Description: Proposed motor vehicle repair
shop

Location: Plots 12 & 13
Enterprise Way
Pinchbeck
Spalding

Amendment: Revised site layout
Dwg nos. LDA/091/03B & LDA/091/04

ACKNOWLEDGEMENT OF AMENDMENT

Drawing
SECURE COMPOUND
GENERAL ARRANGEMENT

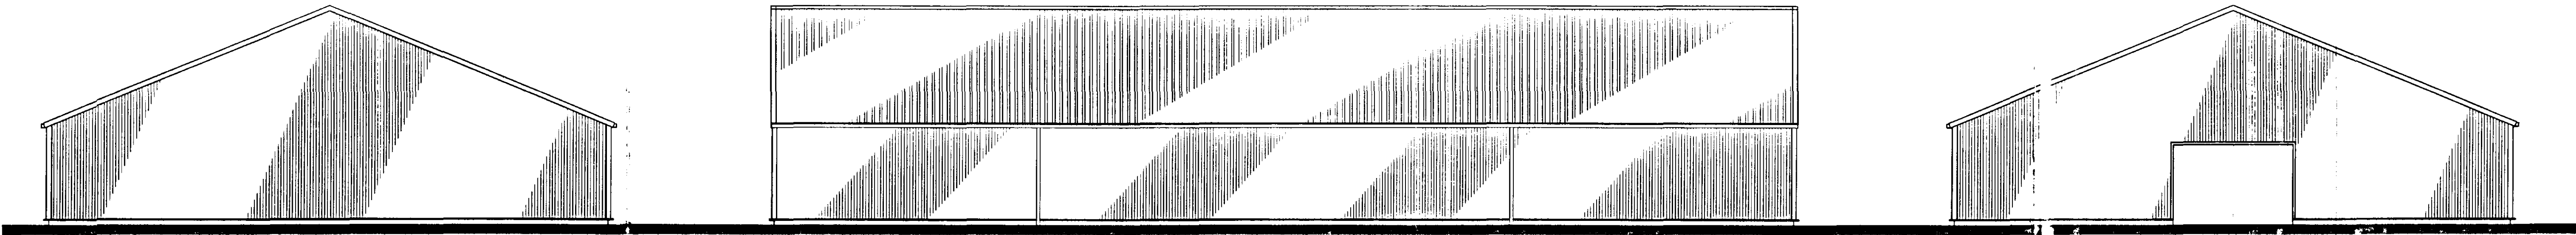
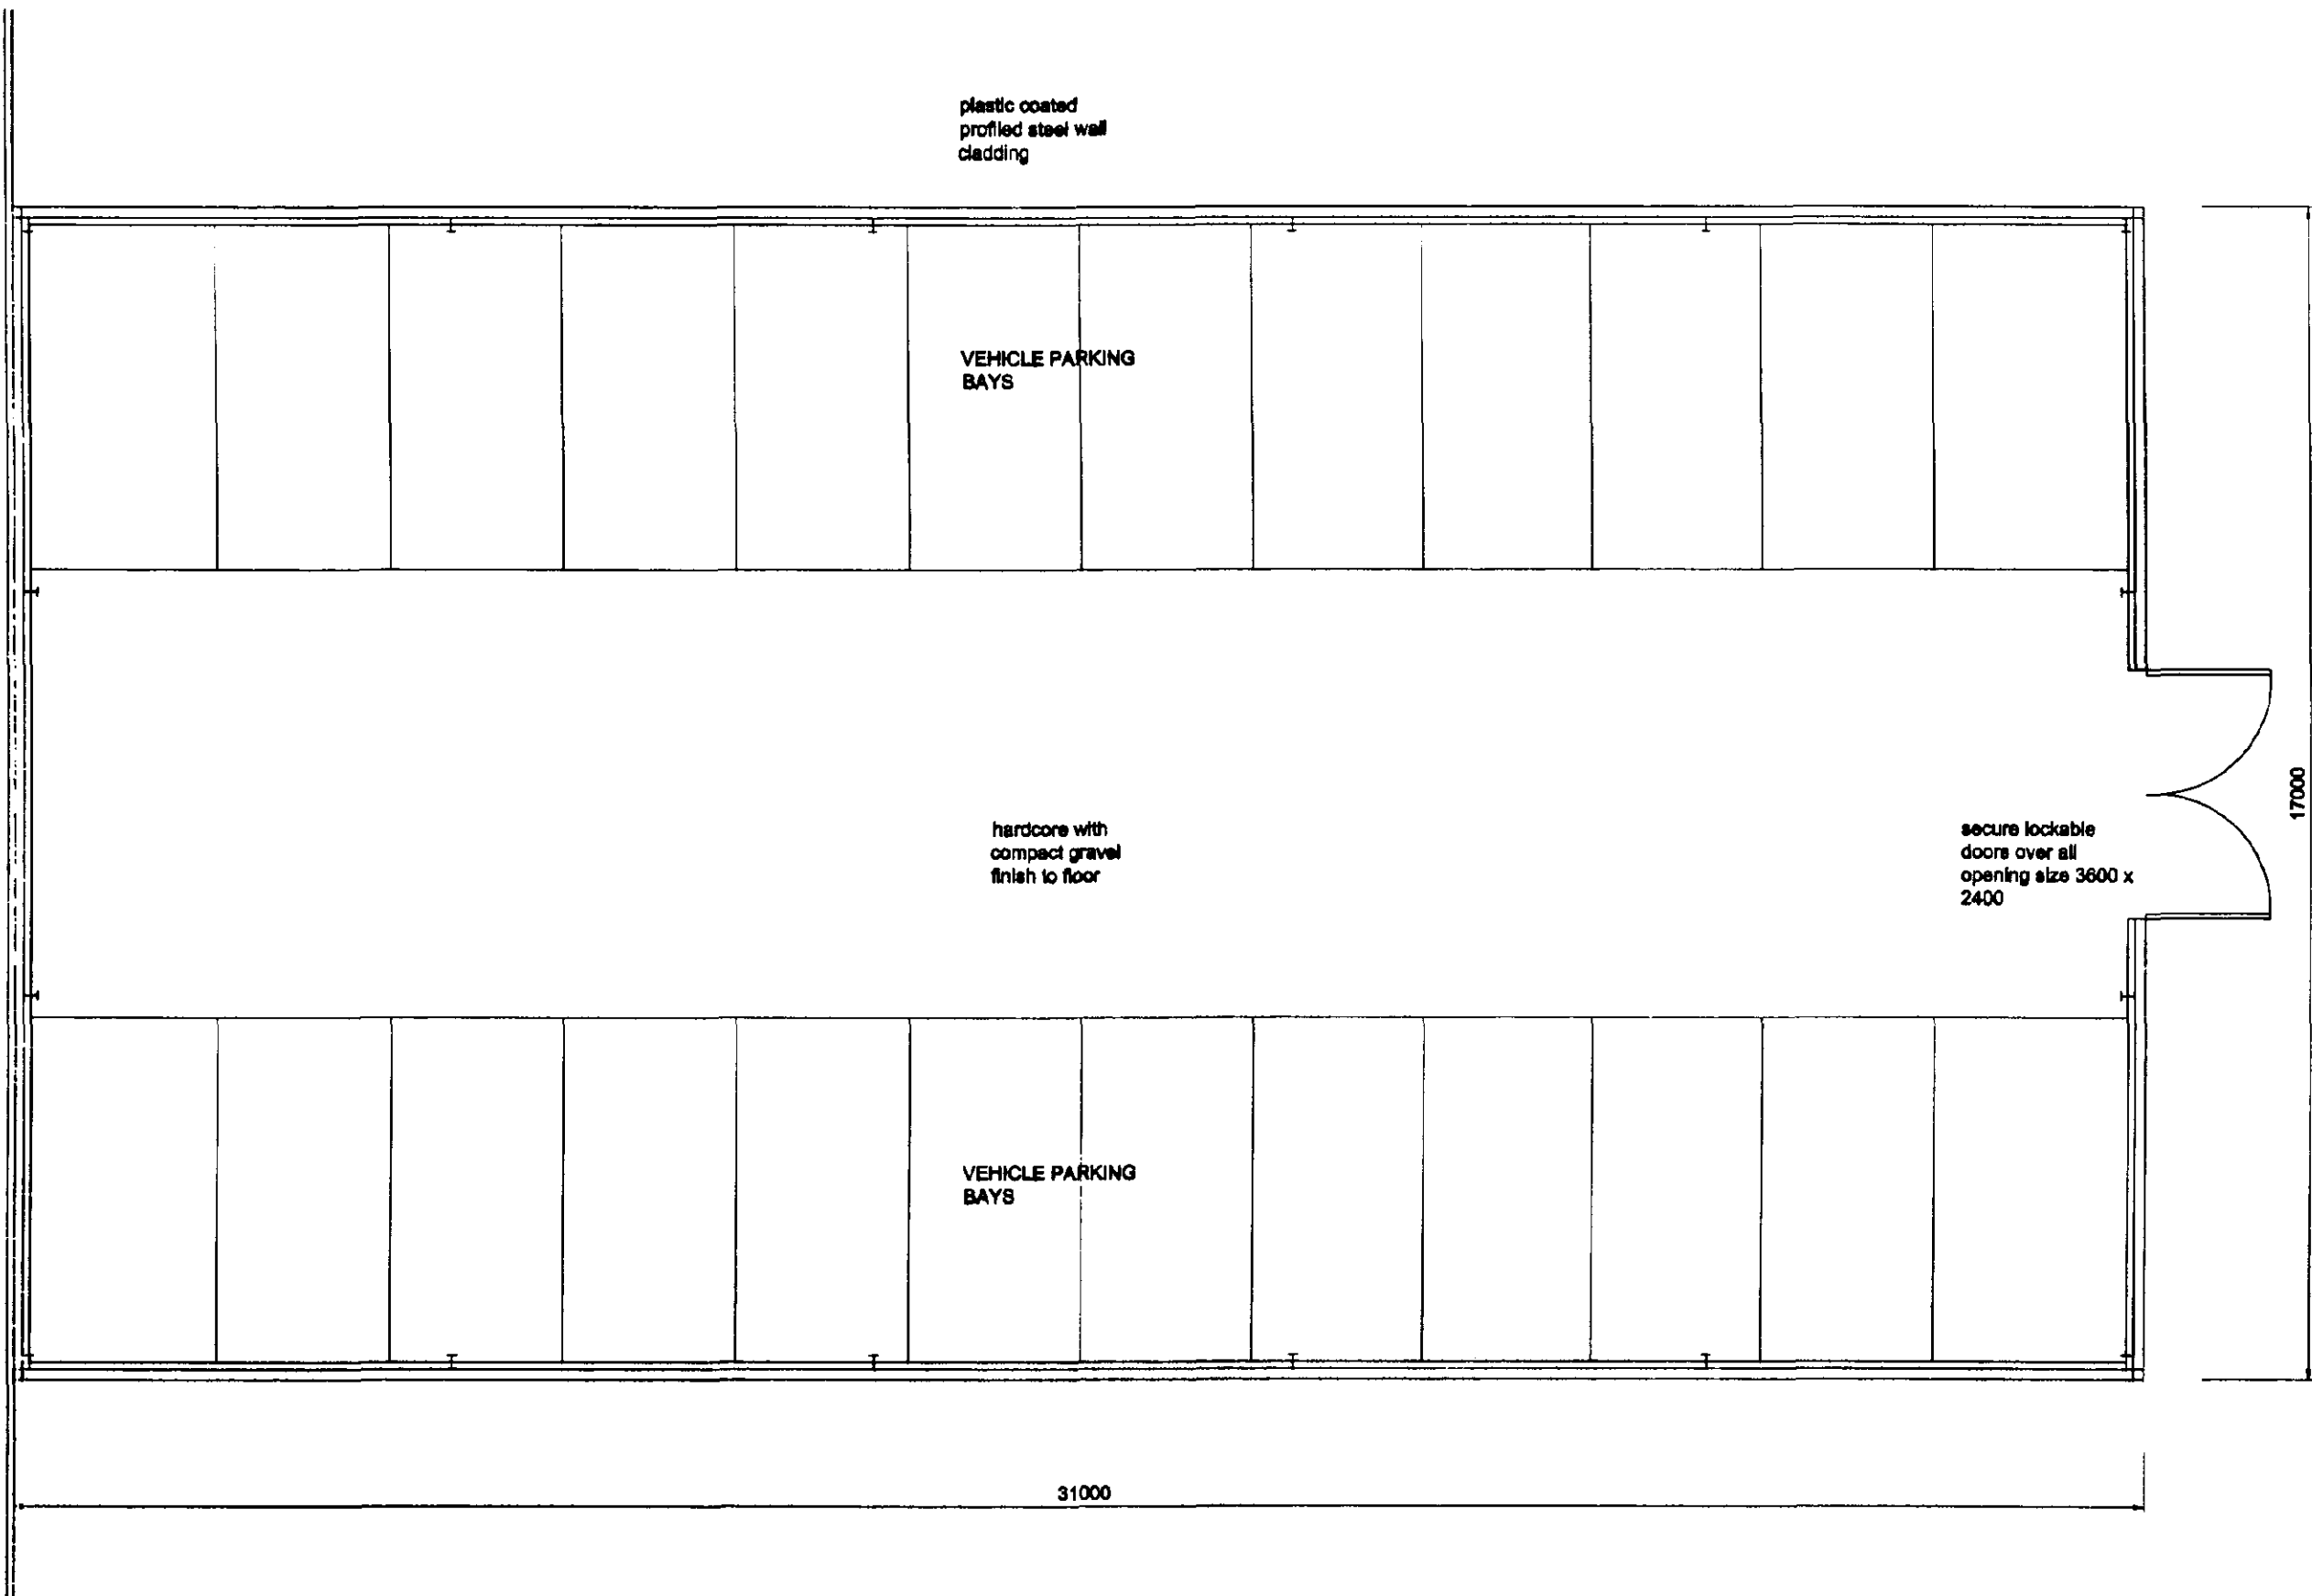
We also enclose herewith four copies of drawing number LDA/091/04 showing the proposed secure vehicle store.

Drawing
ELEVATIONS

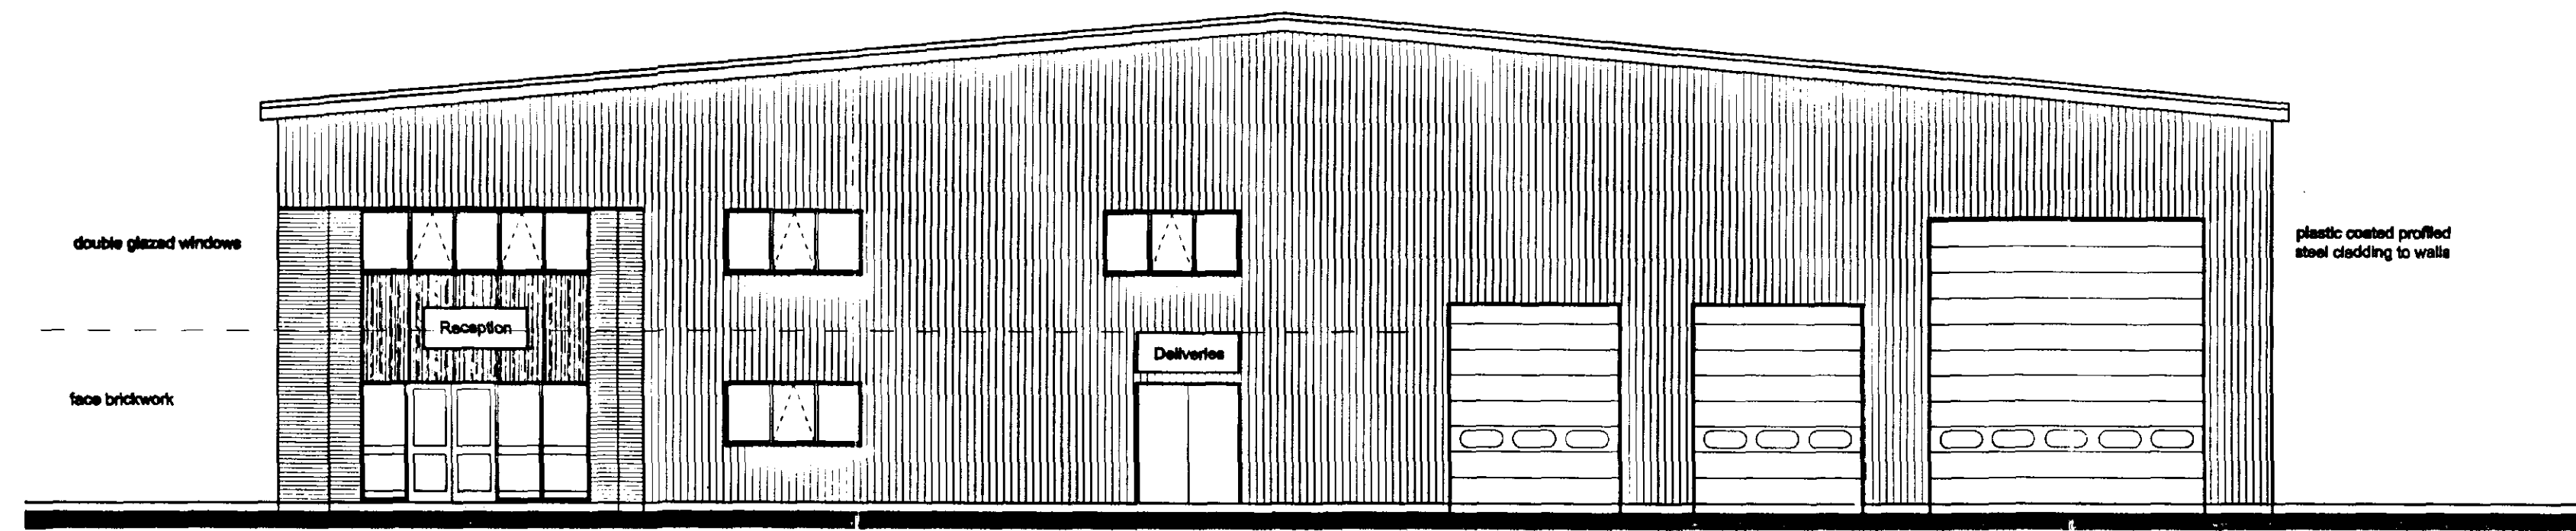
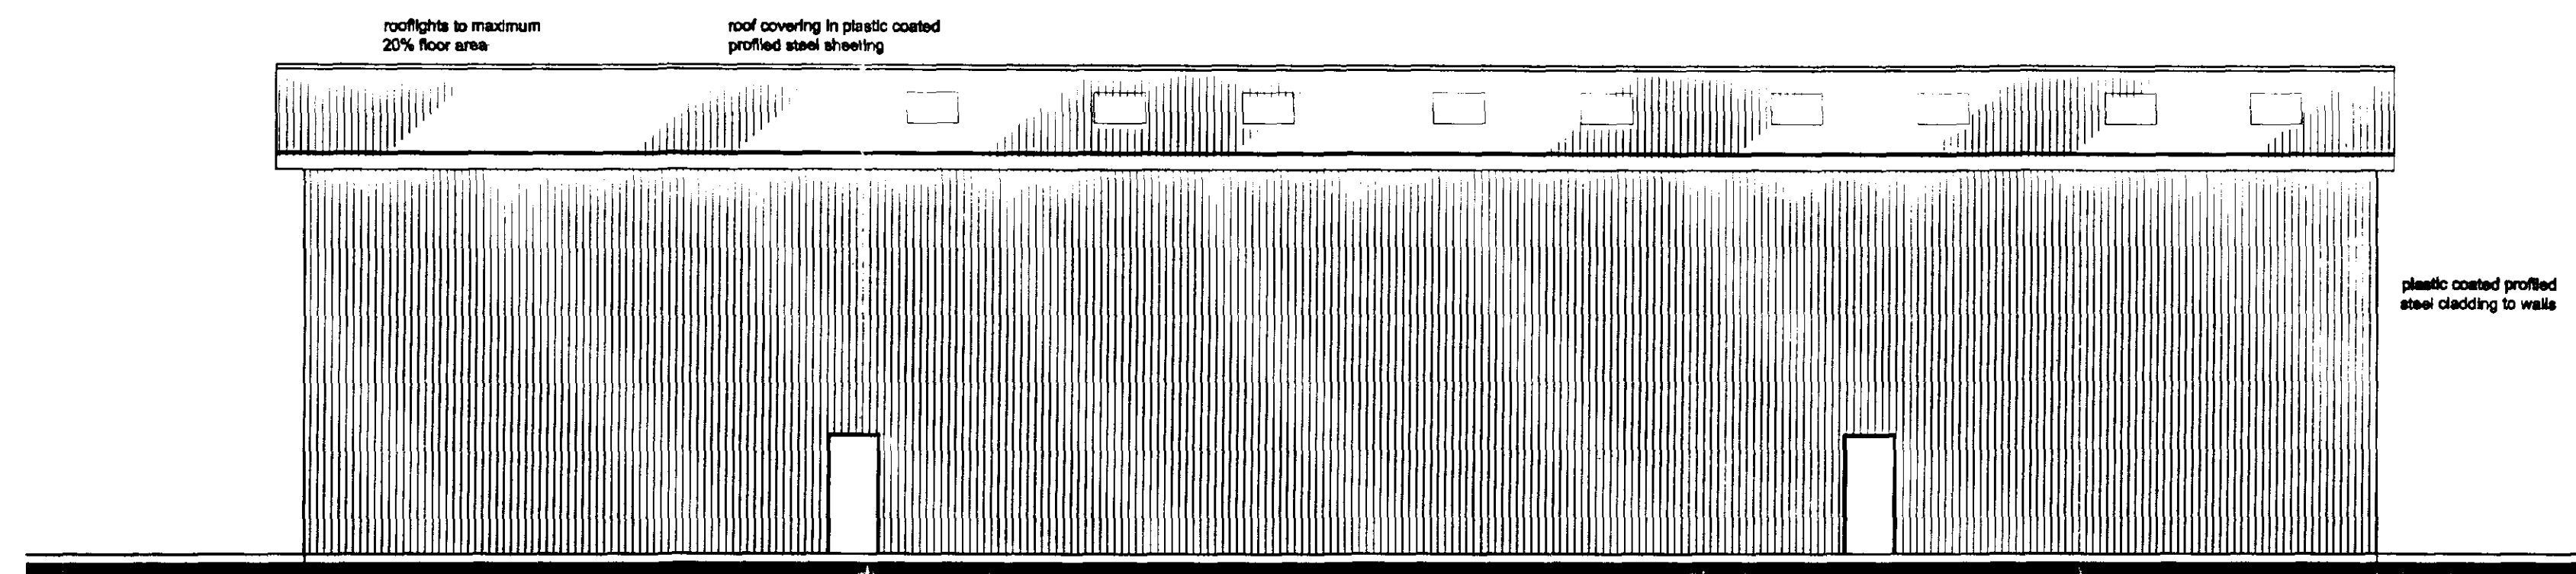
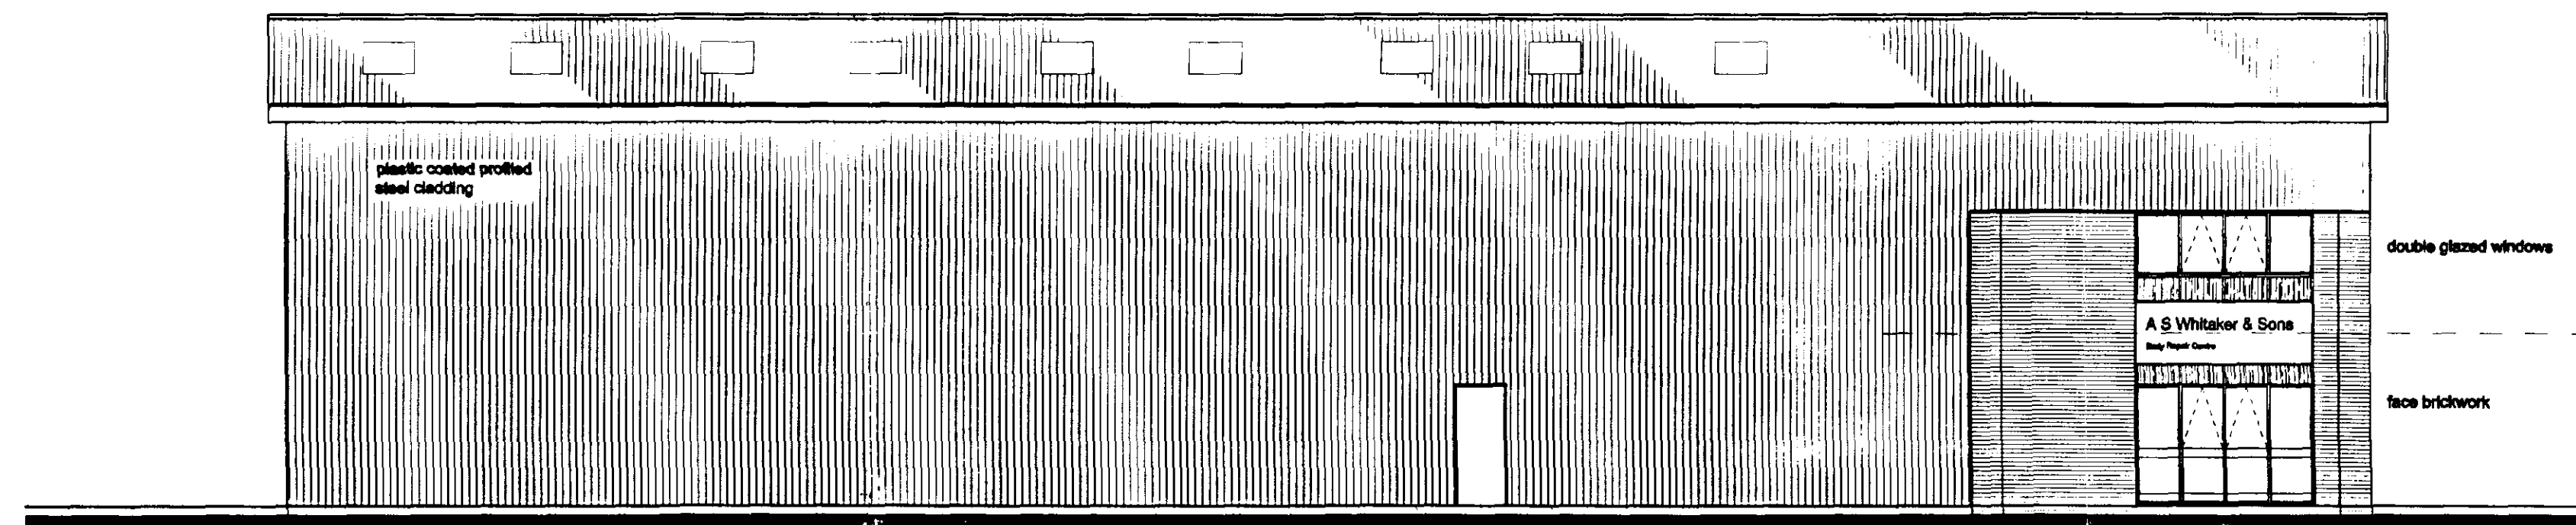
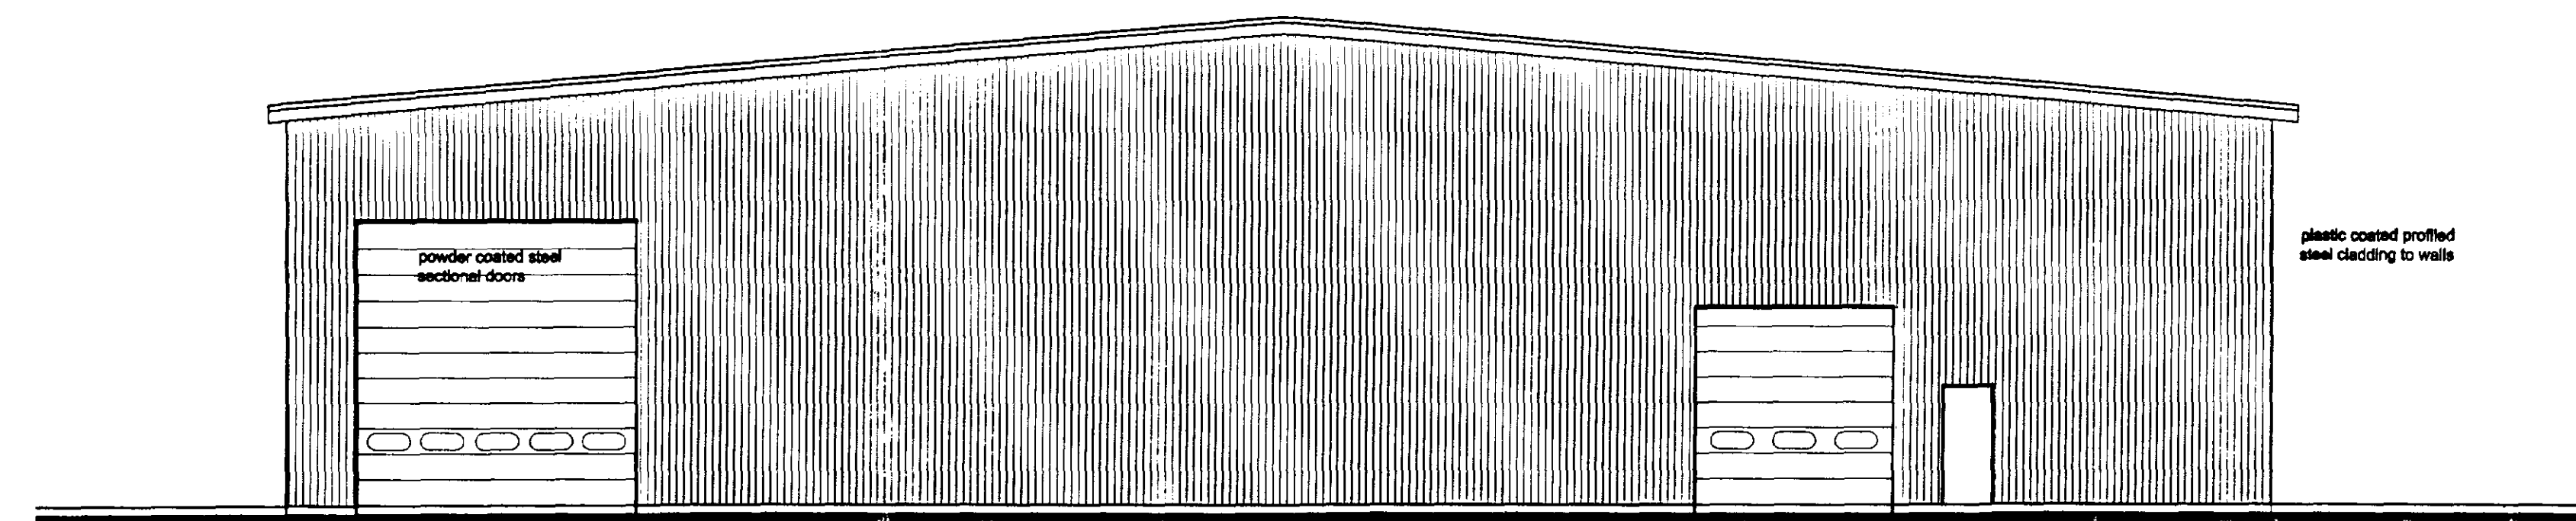
REDUCTION IN AMOUNT OF BRICKWORK
TO ELEVATIONS TO RECEPTION
AREA

Amendment: Reduction in amount of brickwork to reception elevations
Dwg.No.LDA/091/02 Rev.B

Further to the recent conversation between yourself and the writer. We enclose herewith two copies of drawing number LDA/091/02B showing amendments to the elevations, together with two planning amendment forms duly completed.

The amended details submitted in respect of the above proposal have now been considered and there are no objections to the amendment being implemented to the extent described above.
